Our ref: DOC19/909510

Senders ref: SSD 9809 (Blacktown)

Subject: Request for Advice – New Marsden Park Public School, Blacktown (SSD 9809) (Blacktown)

I refer to your e-mail dated 18 October 2019 requesting comments from the Environment, Energy and Science Group (EES) in the Department of Planning, Industry and Environment on the exhibition of the EIS for the New Marsden Park Public School, Blacktown (SSD 9809).

Figure 7 – Flood Prone Land (Source: Marsden Park Precinct, NSW Planning & Environment June 2016)

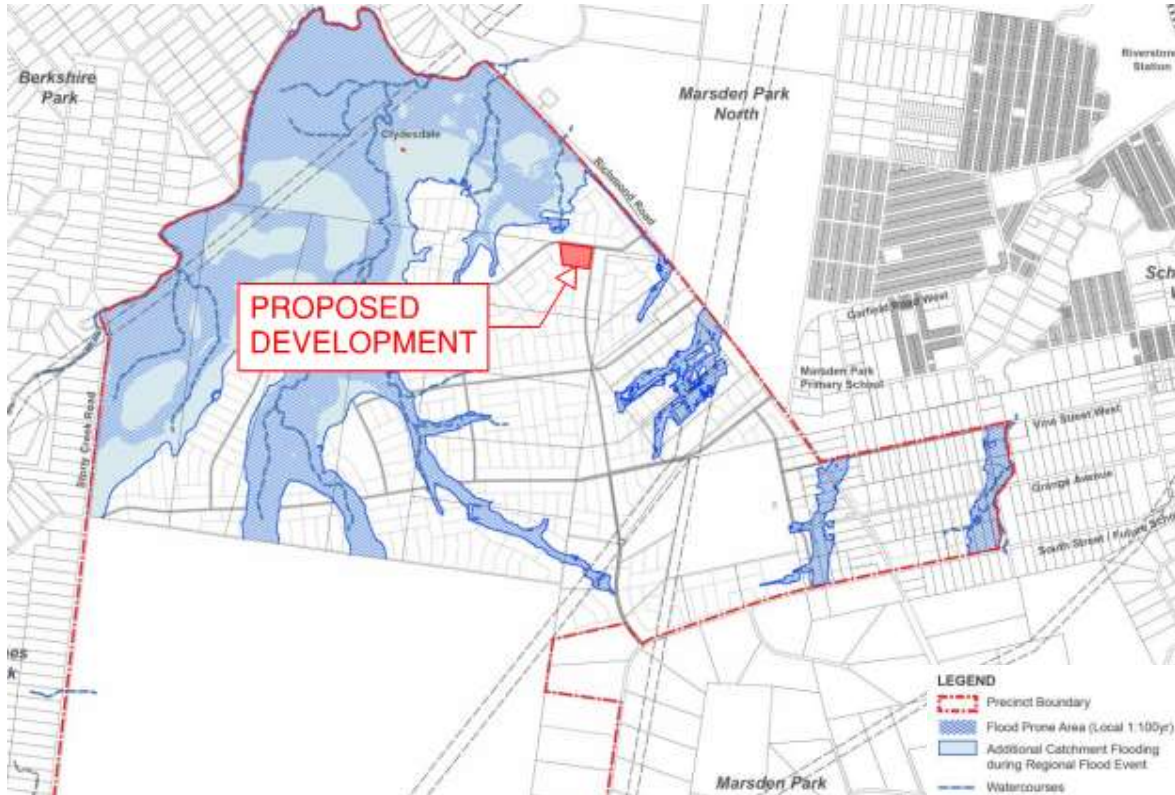
The Environmental Impact Statement does not include an adequate flood impact assessment for the proposed development.

Rather, the Stormwater Management Plan prepared by Wood and Grieve, dated July 2019 includes a section titled 'Flood Impact Assessment', which briefly states '*Wood and Grieve have reviewed Council flood maps, Development Control Plan (DCP) and the Marsden Park Precinct DCP and have determined that the site is located outside flood planning areas. The proposed development is not impacted 100-year ARI flooding*'.

The above statement shows a lack of understanding of the floodplain risk management issues associated with the full range of flooding up to the probable maximum flood. For example, the relevant site is within the Hawkesbury-Nepean regional flood extent and the proposed development is a sensitive land use as its users are vulnerable to flooding and have difficulties in responding to an emergency. The statement also shows a lack of understanding of the Secretary's Environmental Assessment Requirements as outlined in Section 18 of the SEARs.

EES strongly recommends that an adequate Flood Impact Assessment (FIA) be undertaken by an engineering consultancy specialising in flood modelling to address floodplain risk management aspects as outlined by the SEARs. The FIA should be referred to EES for review.
